Date: 24 November, 2015

Re: Application: SSD 6624
described as "Sly's Quarry Expansion Project"
Applicant: Newman Quarrying Pty Ltd
Location: Jacky Bulbin Road, Tabbimoble Creek, NSW

**Figure 9 Predicted operational noise levels – Scenario 2 – Peak daily production with rock hammer**

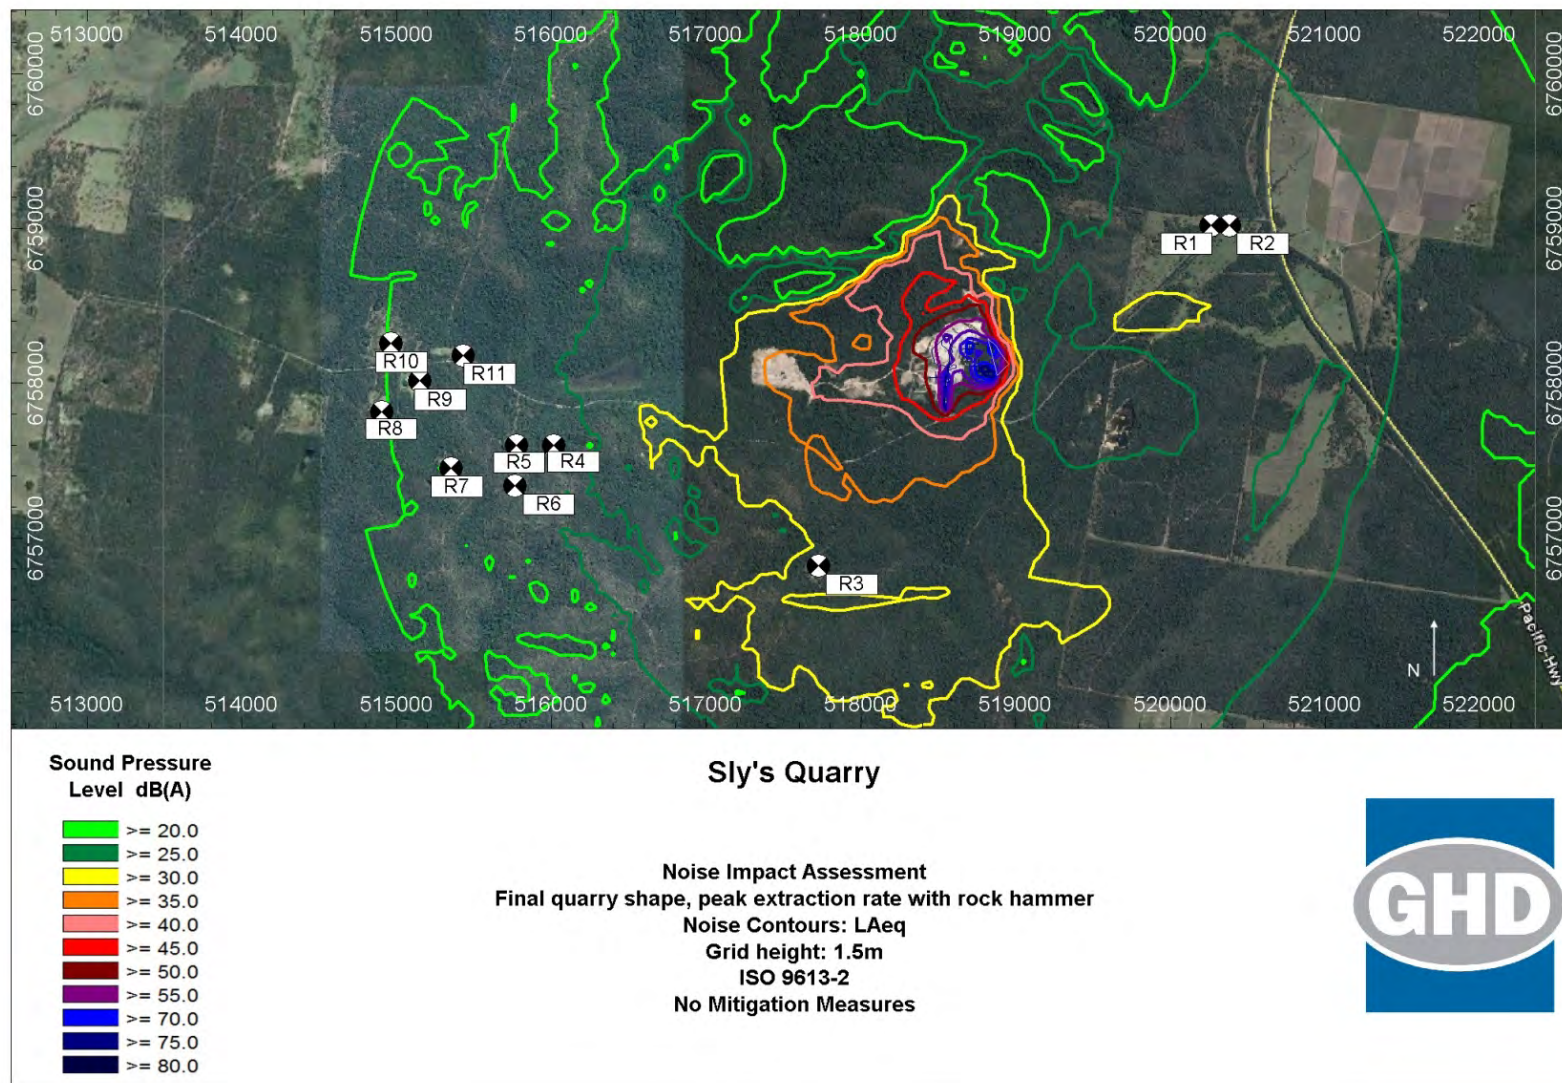
Inspection of Table 5.2 and Figures 4 to 9 in EIS Appendix D - Noise Assessment leads us to conclude that even without direct measurements, that noise levels may well far exceed the requirement to be no greater than 5 dB above background levels at the property boundary.
